Applicant response to Comments from Sarah Burrow by email on 28th April 2023.

Response dated: 23rd May 2023.

filename: w:\1444 wsc - lovell\jvhed\cad2 north bersted\stage 3- p06\1444-hed-dr-02-002-003 hard & soft landscape plans p06.dwg, printed on:2023-07-20 on iso full bleed a3 (297.00 x 420.00 mm) @ 100% of original scale

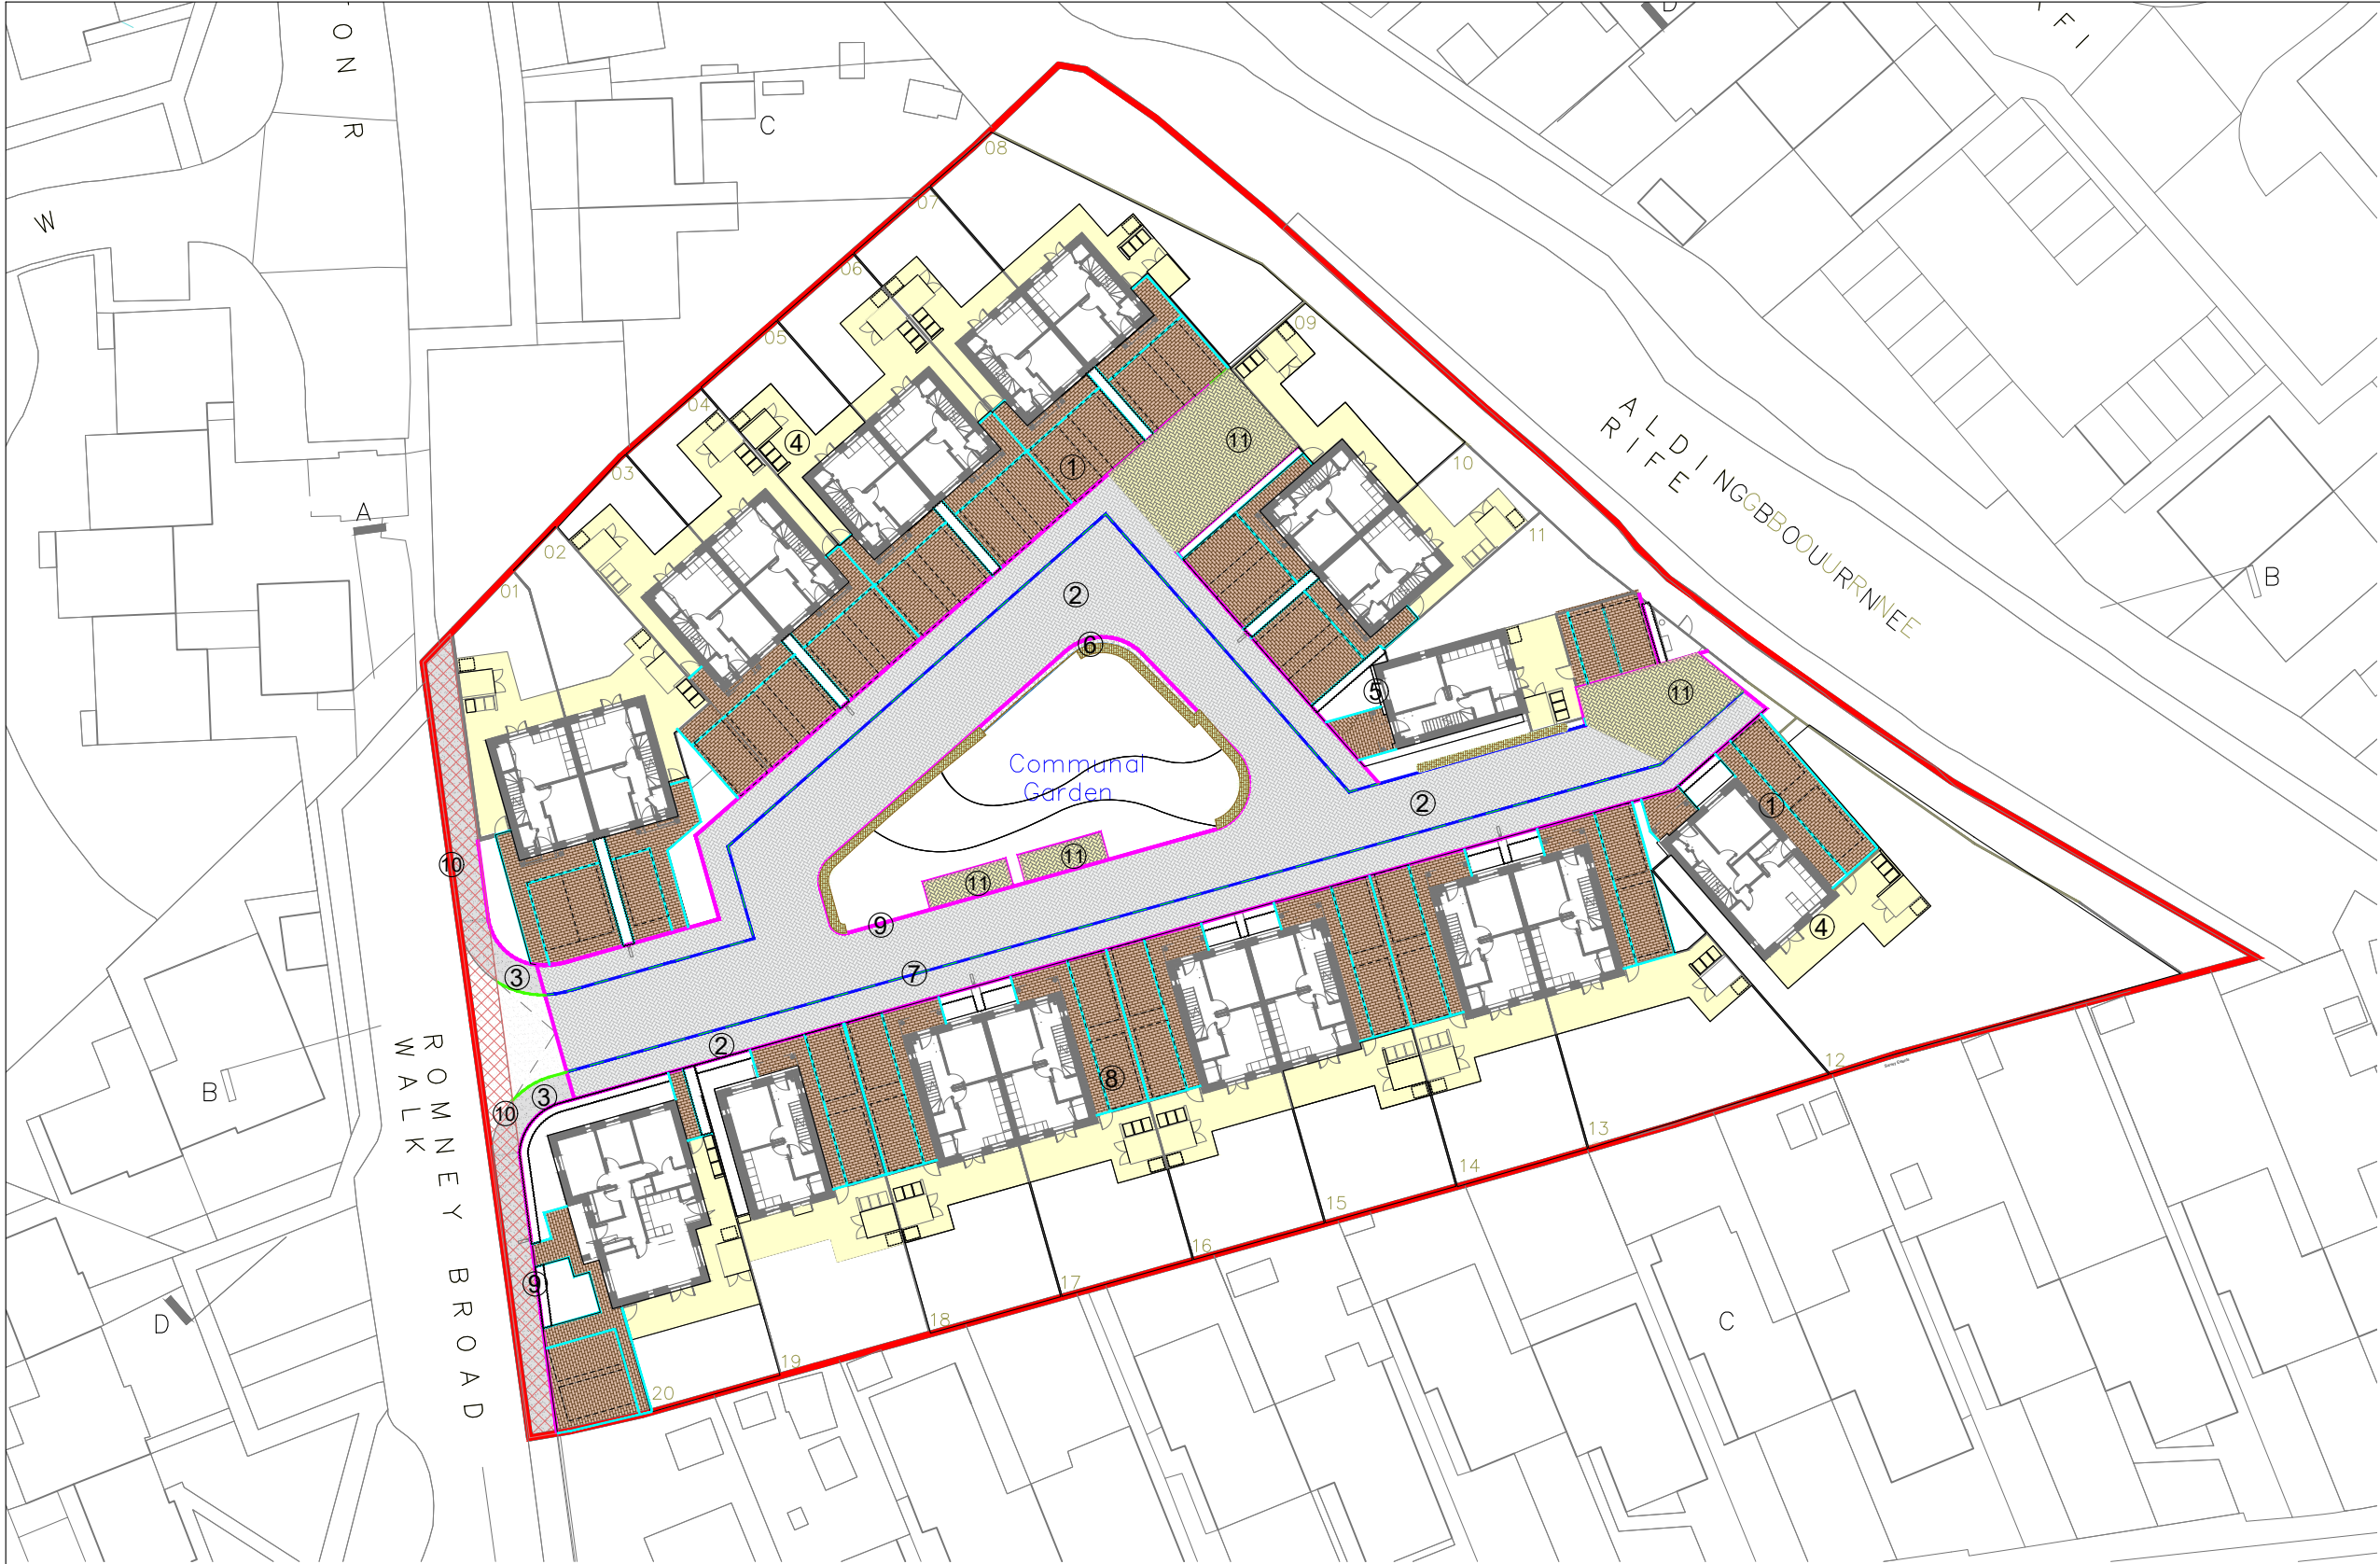
- D. *The current landscaping design proposes one Red Oak tree and 8 Himalayan Birches planted directed over the area where the attenuation tank and storage blanket are proposed. This is inappropriate – drainage infrastructure and trees must not conflict. Tree roots have the potential to damage pipes, the tank and blanket liners which can cause groundwater ingress, loss of capacity and connectivity. Furthermore the location of substantial drainage apparatus within 0.3m of ground level is likely to inhibit the growth of the proposed trees – please consult the landscaping officer in this regard.*

- E. *There also appears to be a proposed Quercus Rubra (Red Oak) located directly over the proposed outfall pipe east of plot 11. It is likely that this tree will need to be removed or relocated in the landscaping proposals.*

4. We require the fences to be at least 3m from top of bank, between the development and ancient watercourse, to ensure that the proposals are in accordance with our land drainage byelaws. This easement should be delineated and confirmed on the drainage layout plan. From the information provided it appears that a 2m easement (approximately) has been provided for access and maintenance of the watercourse at present. It is recognised that no buildings are located within 5m (as is also required).

ADC: OK thank you. The same easement will need to be shown on all proposed site layouts and landscaping plans going forward.

We have coordinated with the landscape architect and the trees are now away from the tank. The tree pits eat into the storage blanket and we have taken this into account within the storage calculations. Please refer to the updated landscape architect's information (attached in the WeTransfer link) for details of the tree pits showing root barriers which will prevent ingress of roots into the adjacent drainage infrastructure.

This is now shown moved away from the outfall on the updated Soft Landscape Plan included within the WeTransfer link.

Please see Landscape Architects drawings attached in WeTransfer link.
